# YORKSHIRE GARDENS TRUST

04 November 2025

## **2025/62/92782/E Land off Litherop Lane, Clayton West, Huddersfield, HD8 9LT Erection of stables and tackroom and use of land for equestrian purposes**

SITE PLAN SCALE 1:200

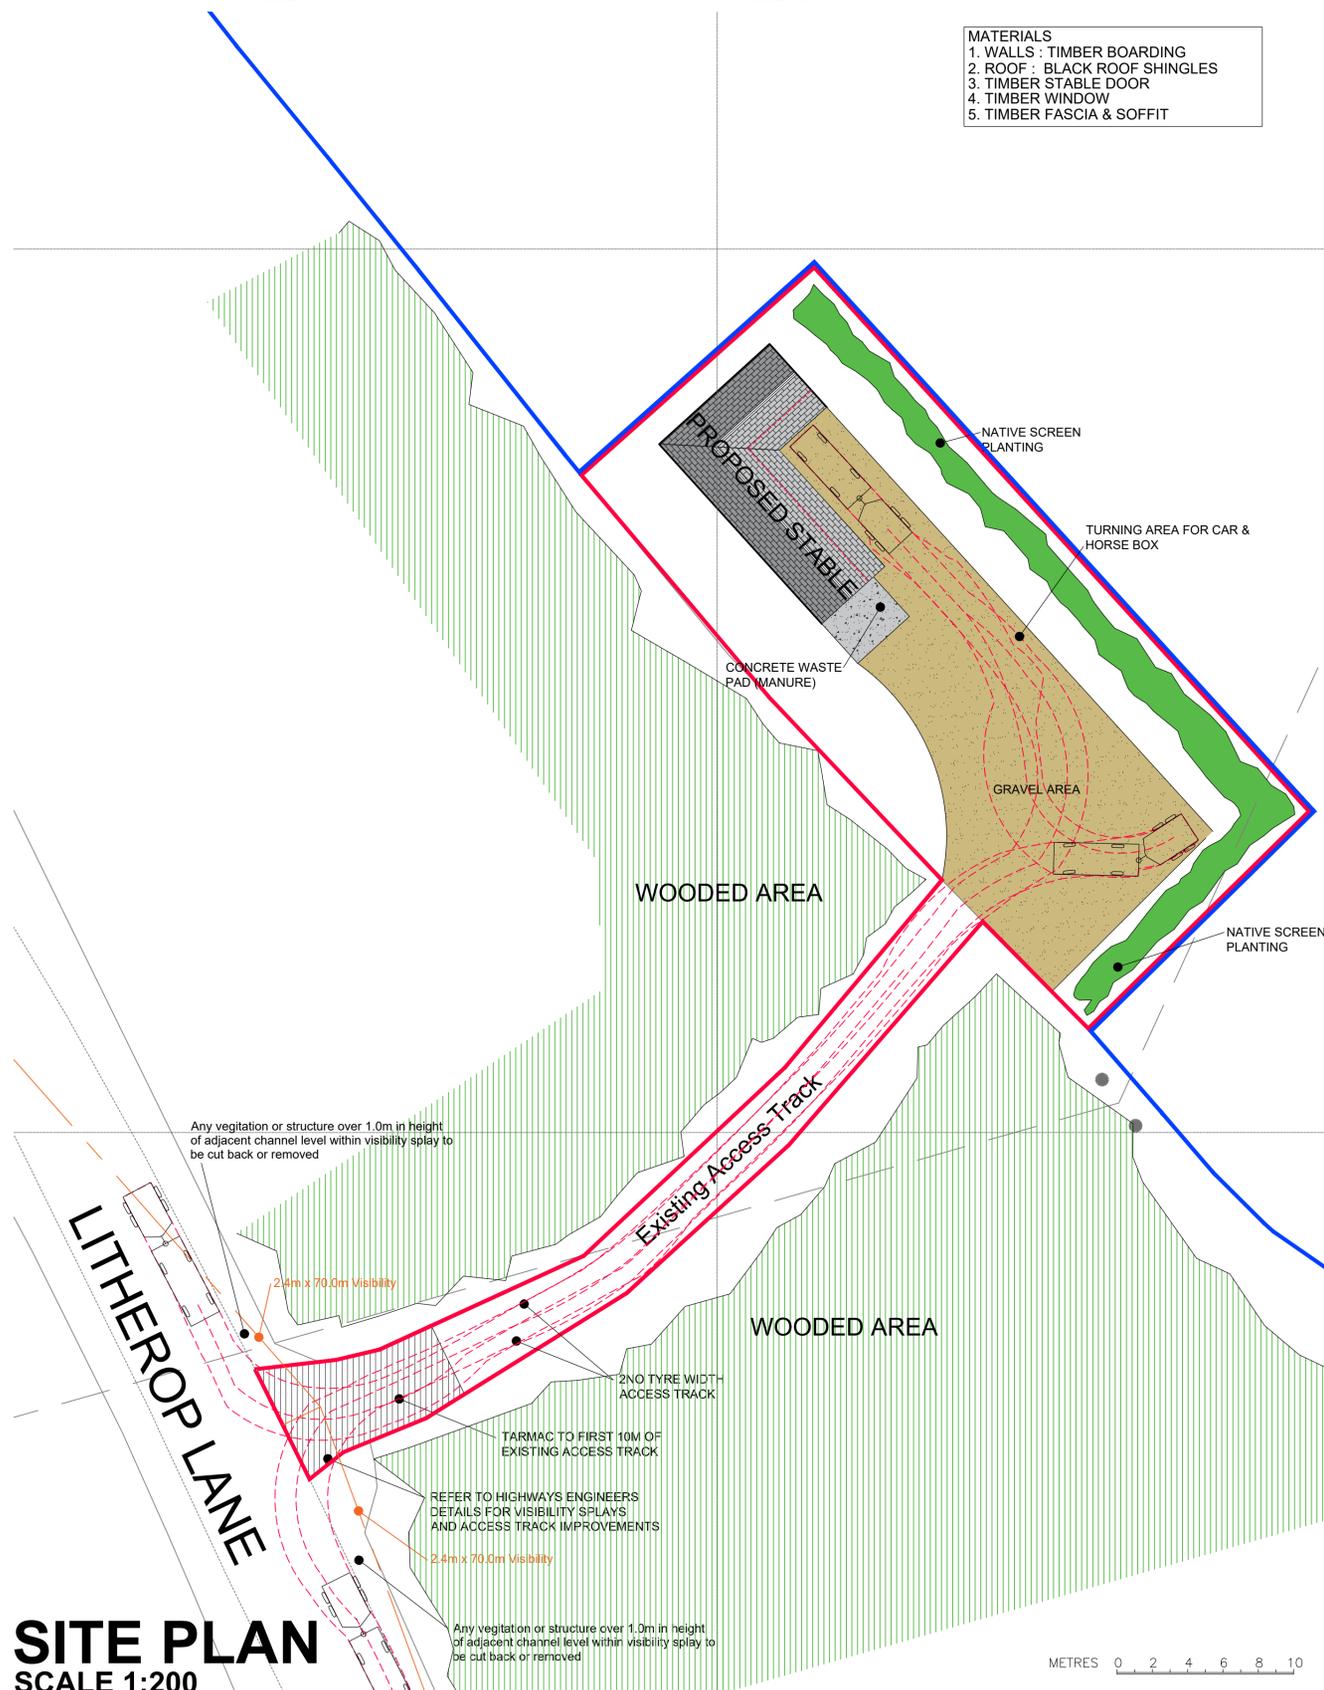
As the proposed site is for a new geometric/rectangular area set into the former parkland (now agricultural land), and thus projecting from the boundary plantation of the RPG via a track, we advise care is taken to ensure that the site blends into the setting on this part of the RPG. For continuity with the historic planting and sympathy with the designed landscape we recommend that several trees are planted in the screen hedge to reference the species present in the Park or the boundary woodland.
